Your ref H01/0452/02
Our ref GRM/JJM/451/02

REPLACEMENT BUNGALOW, BIJOU, BARRIER BANK, COWBIT.

Description Reduced layout

Drwg.Nos. 451/02/01A and 451/02/02B

Ref.	Drawing No.
451/02	02B

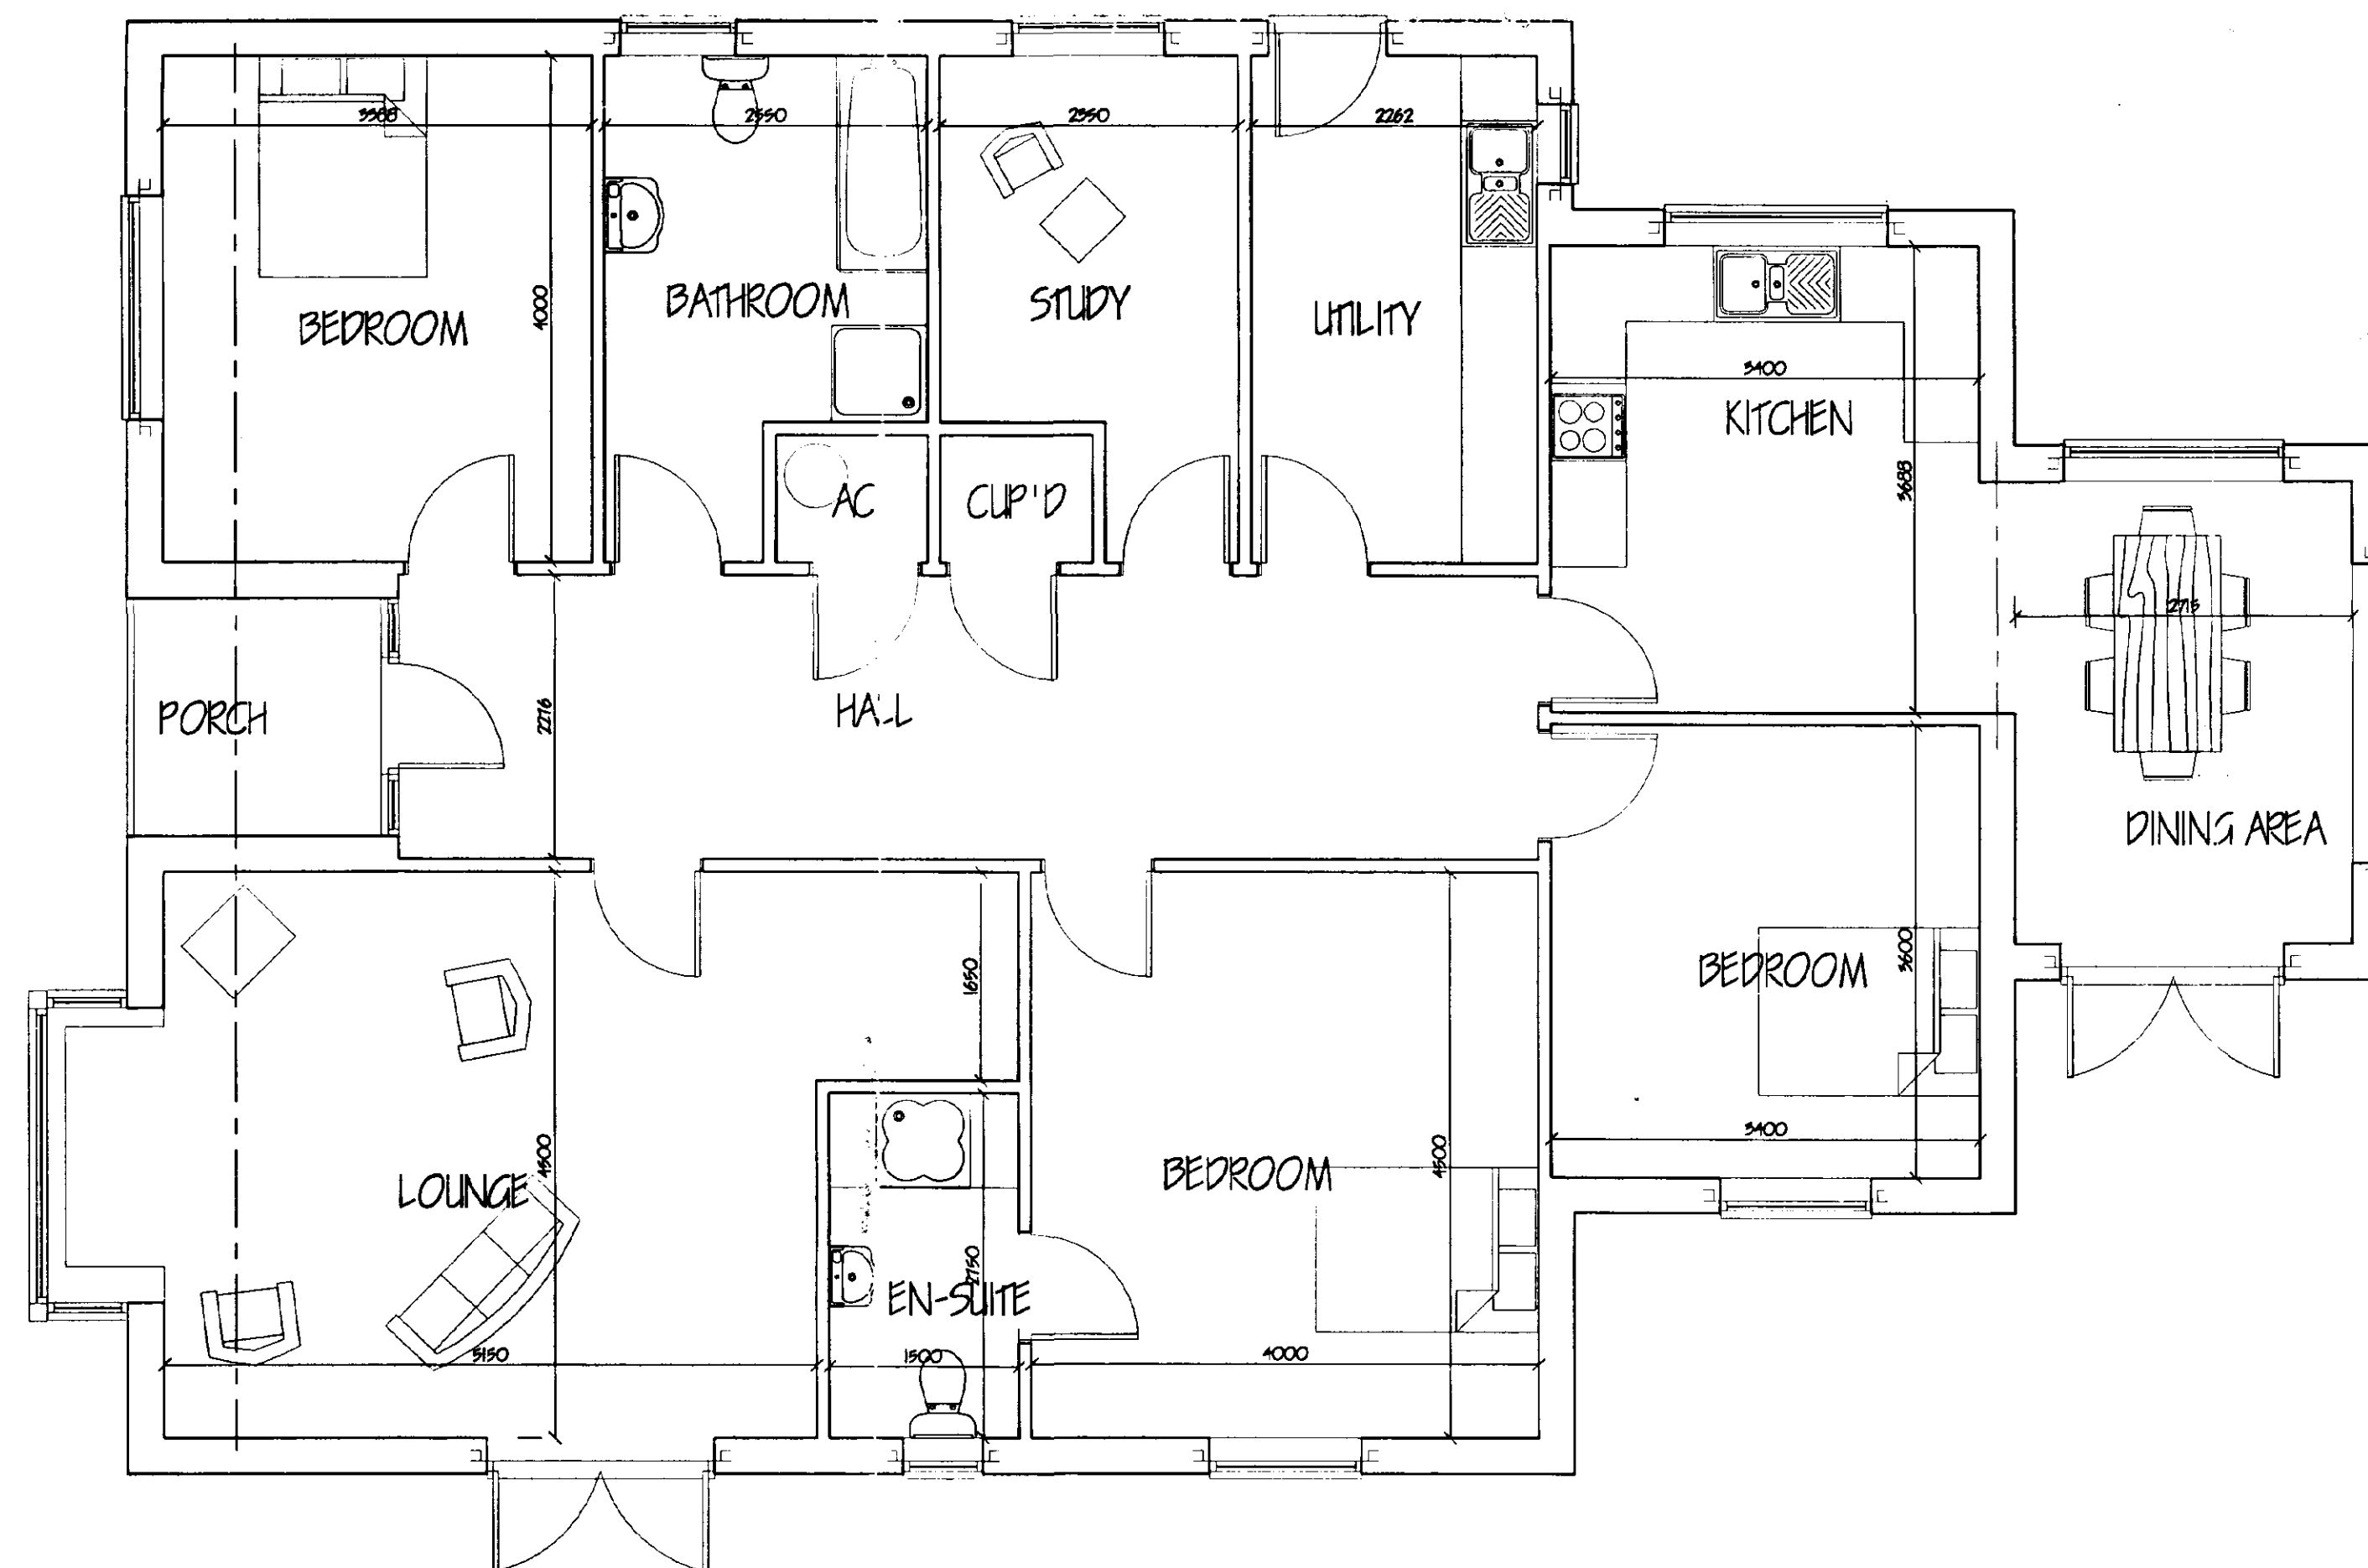
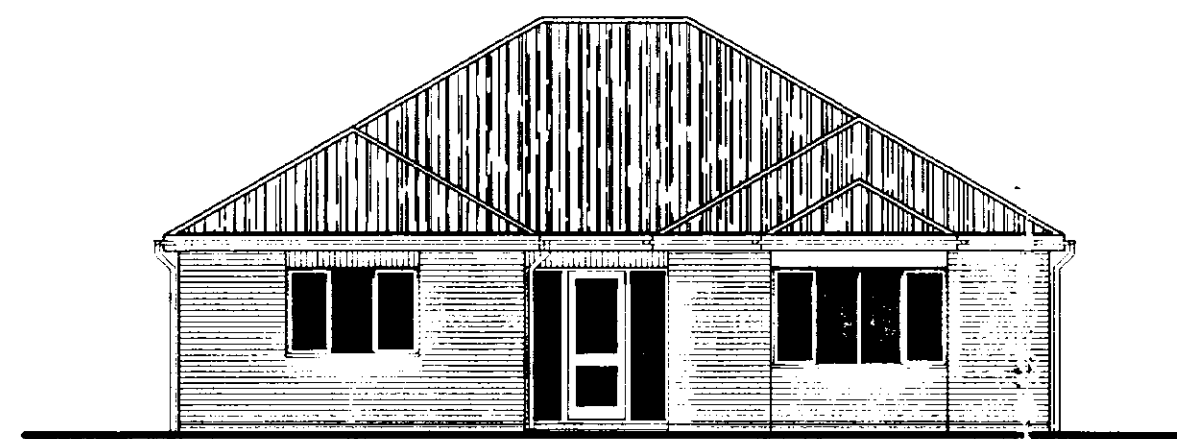
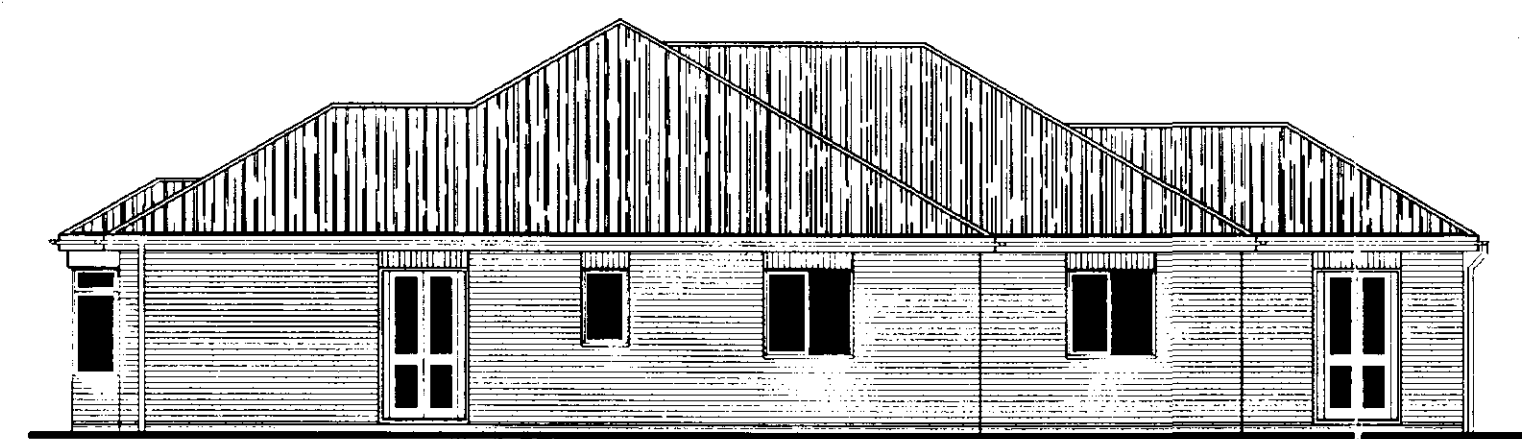
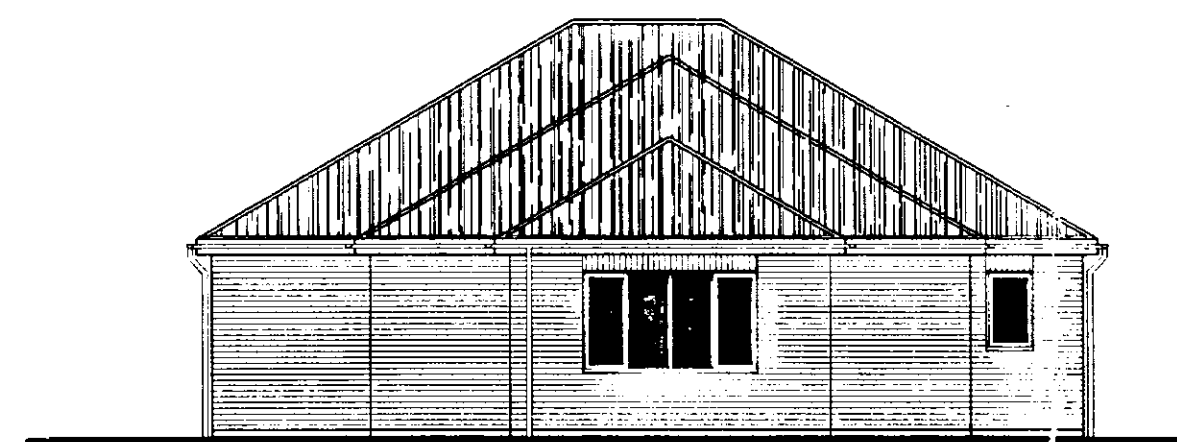
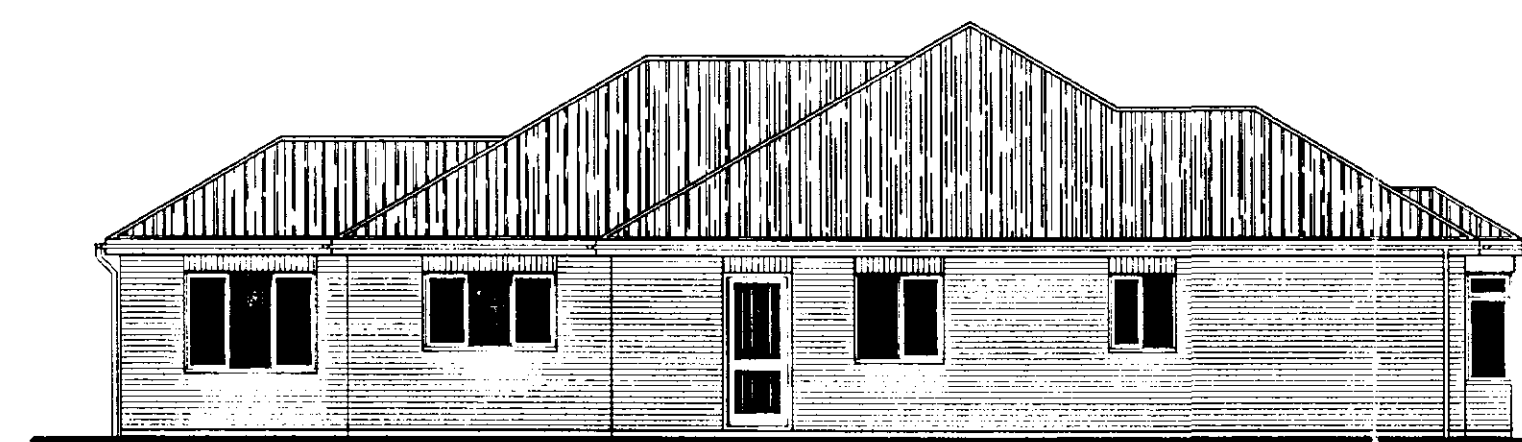
BUNGALOW REDUCTION

REDUCE HALL WIDTH.

REDUCE LOUNGE & MASTER BEDROOM.

REDUCE BEDROOM 2.

REDUCE KITCHEN / DINING AREA.

ROOF DESIGN - INTRODUCE GABLE &

REDUCE PITCH.
